SUBMISSION

Rye Park Wind Farm Modification 1 SSD-6693 – Mod 1

1. I write as the owner of “Wattle Vale”, to object to proposed Modification 1 to Development Consent SSD-6693 for the Rye Park Wind Farm. My objections are on the grounds of visual impacts, noise impacts and biodiversity impacts as set out below. This submission has been prepared with the benefit of advice of senior and junior counsel specialising in environmental and planning law.

FIGURE 2.1.1

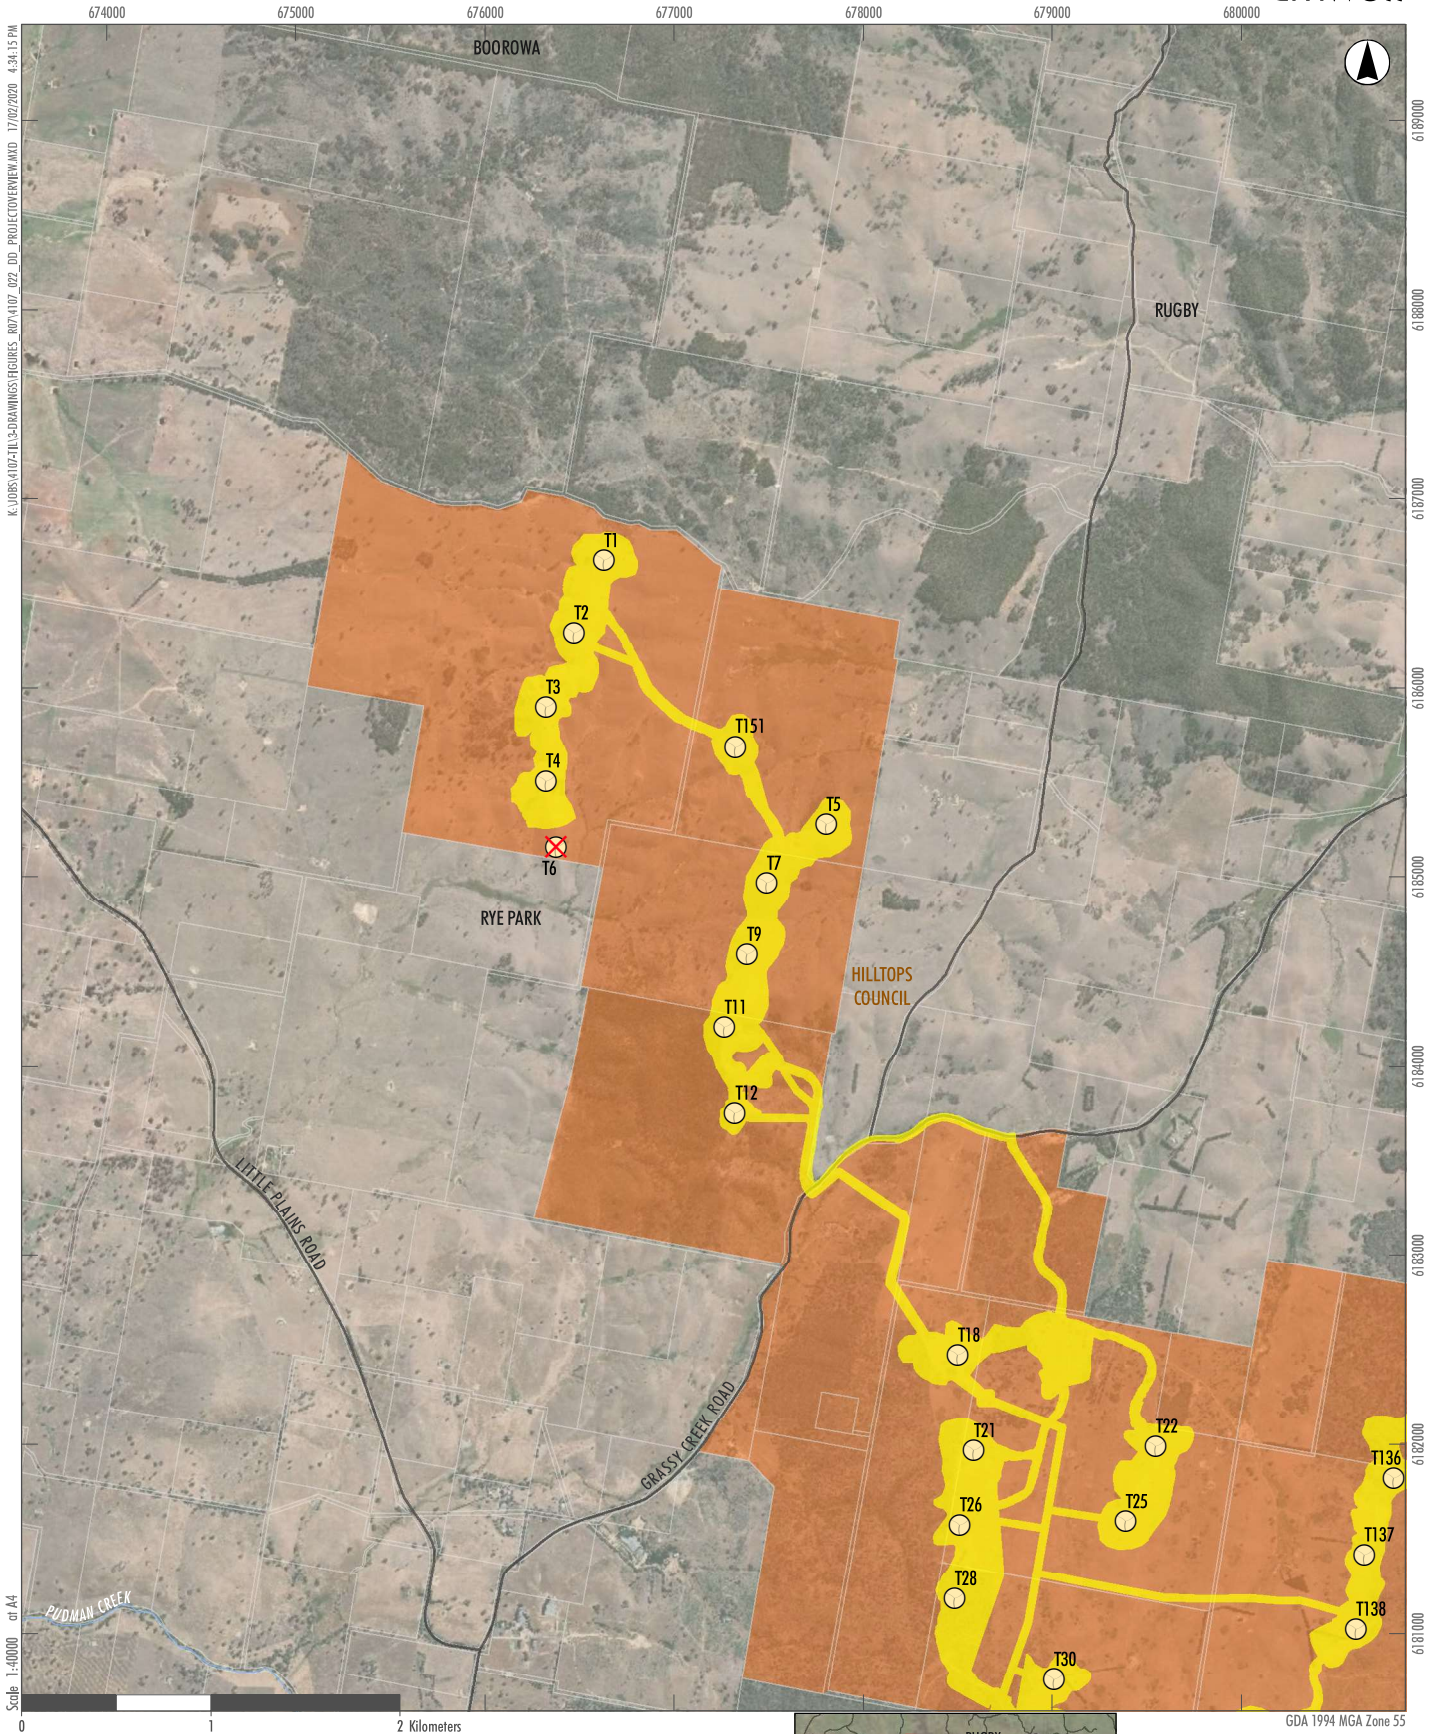
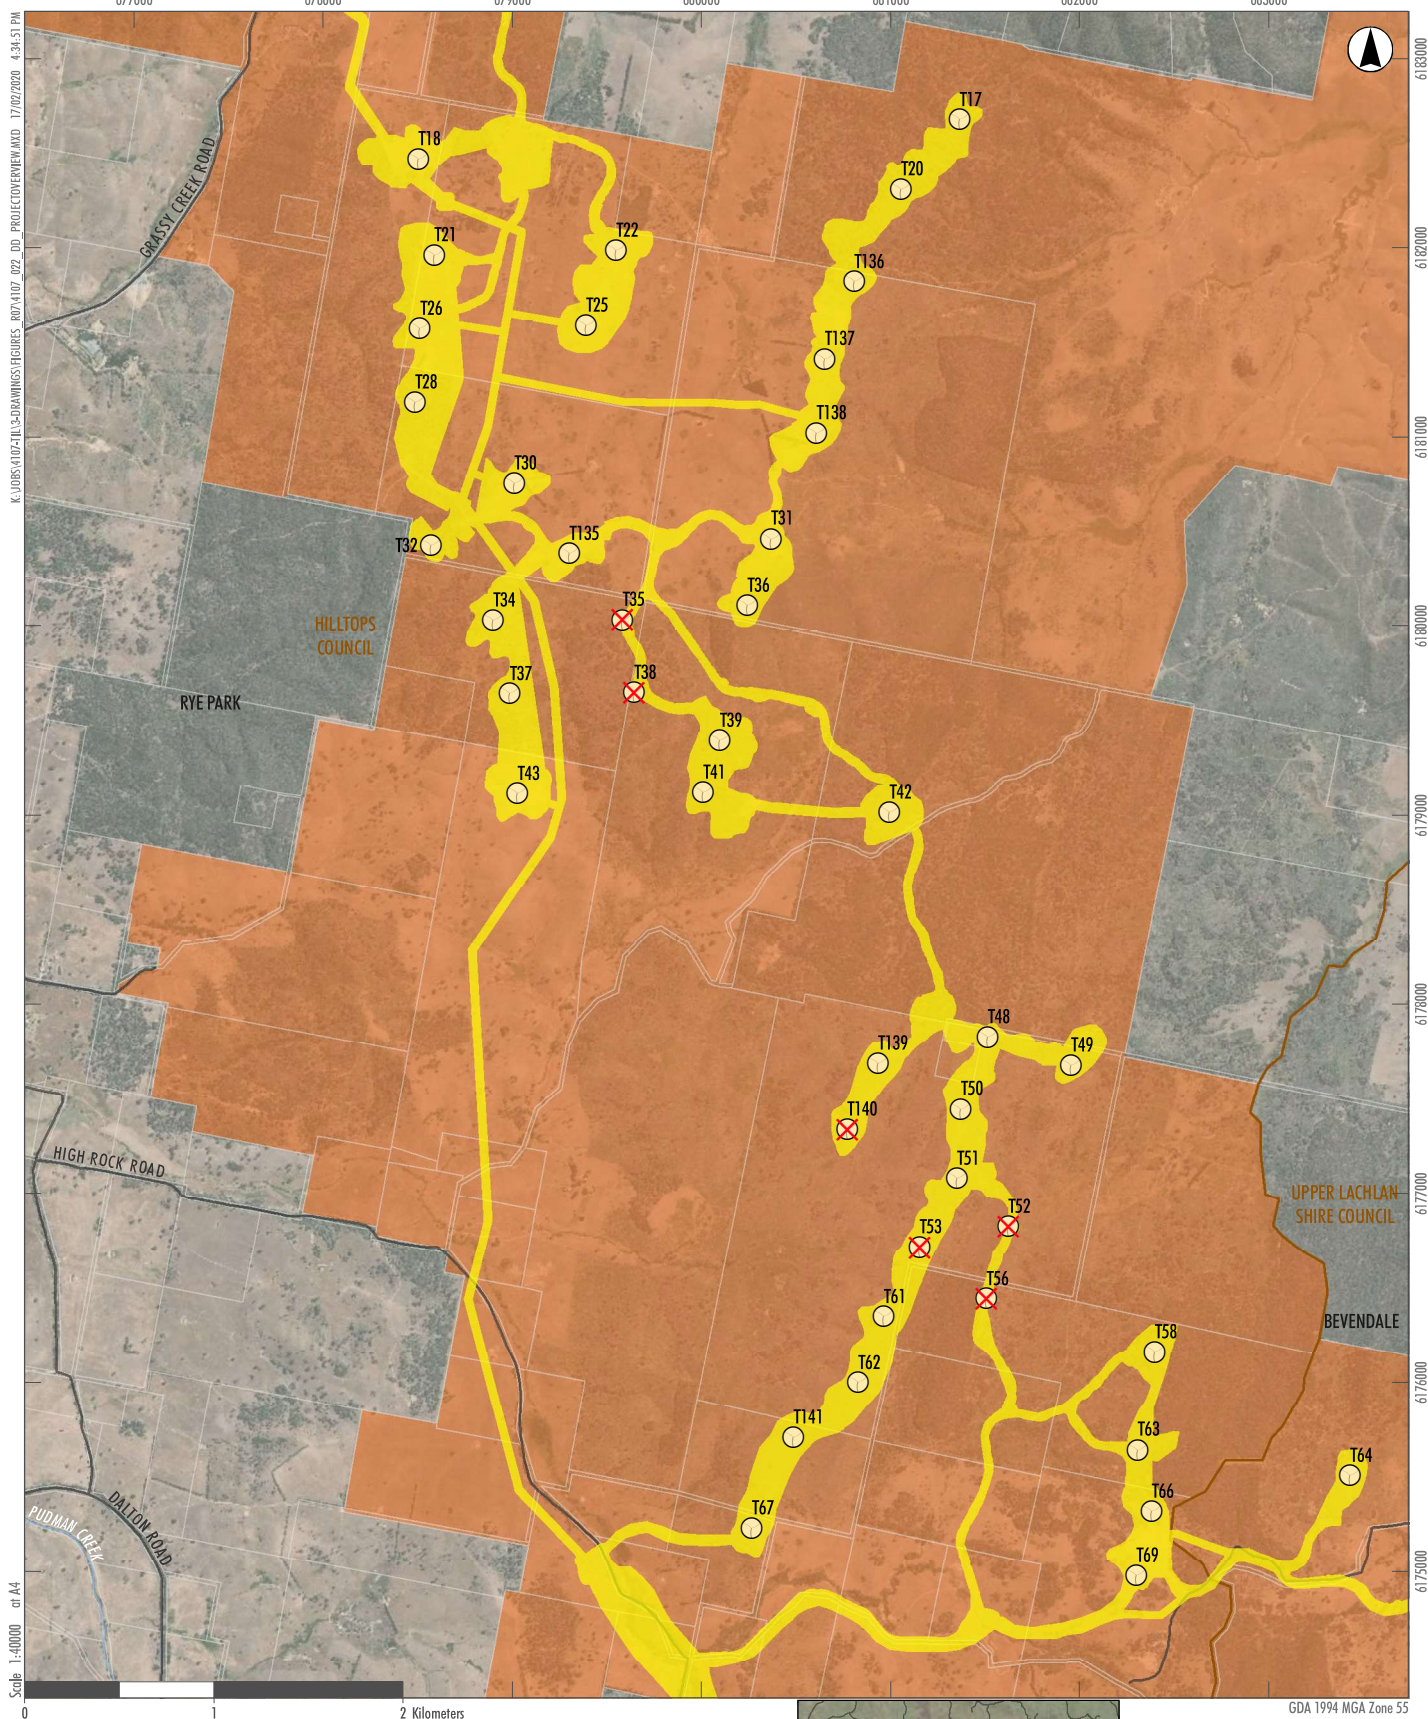
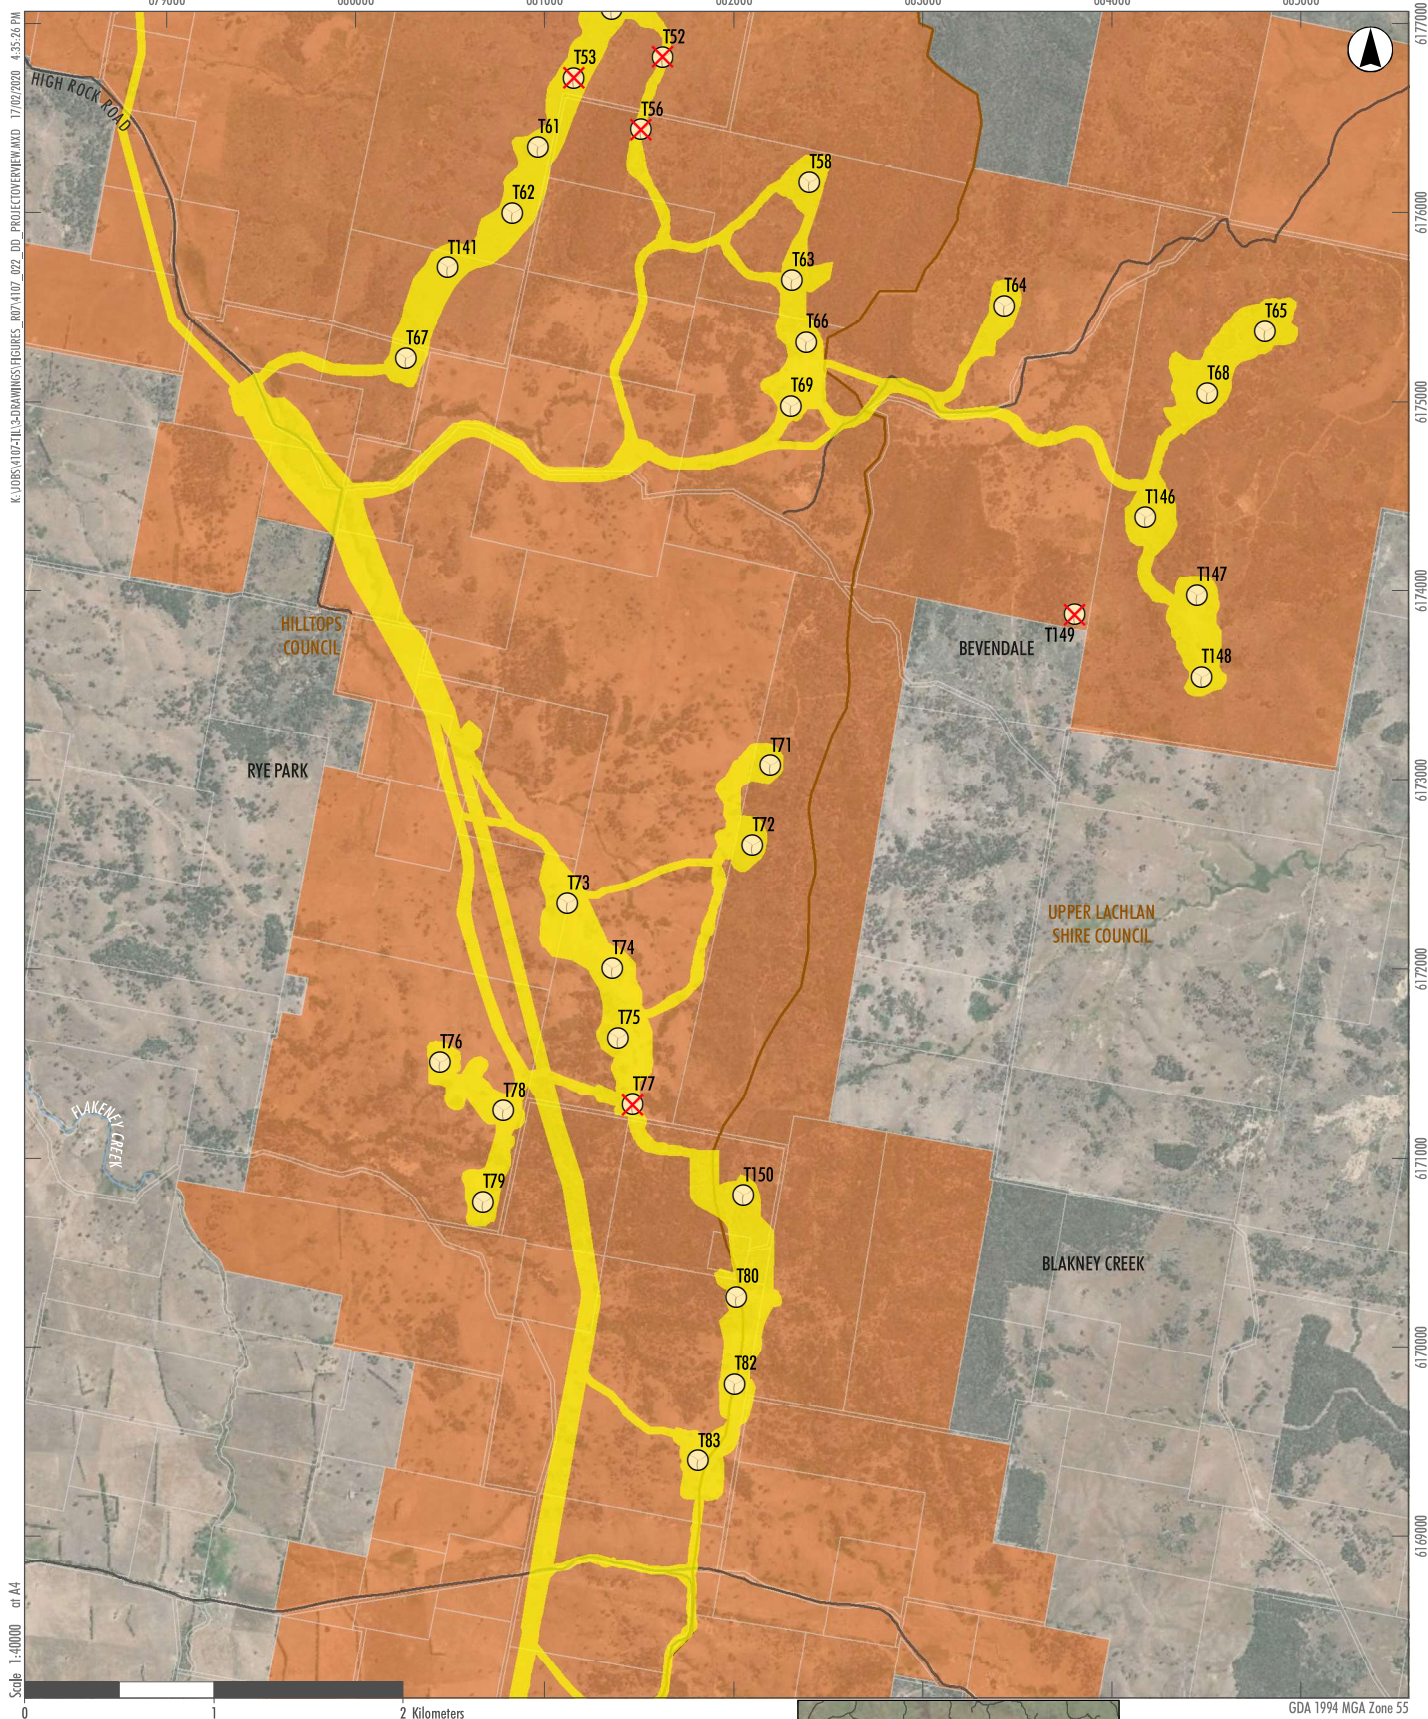
4. The VIA at Fig 1 and 2 contains a plan of the turbines which are to be deleted. However, this actually shows the difference between the Response to Submissions proposal and the modified proposal, rather than between the approved and modified proposal. Thus, it gives the impression of more turbines being deleted as part of the modification application than is actually the case.
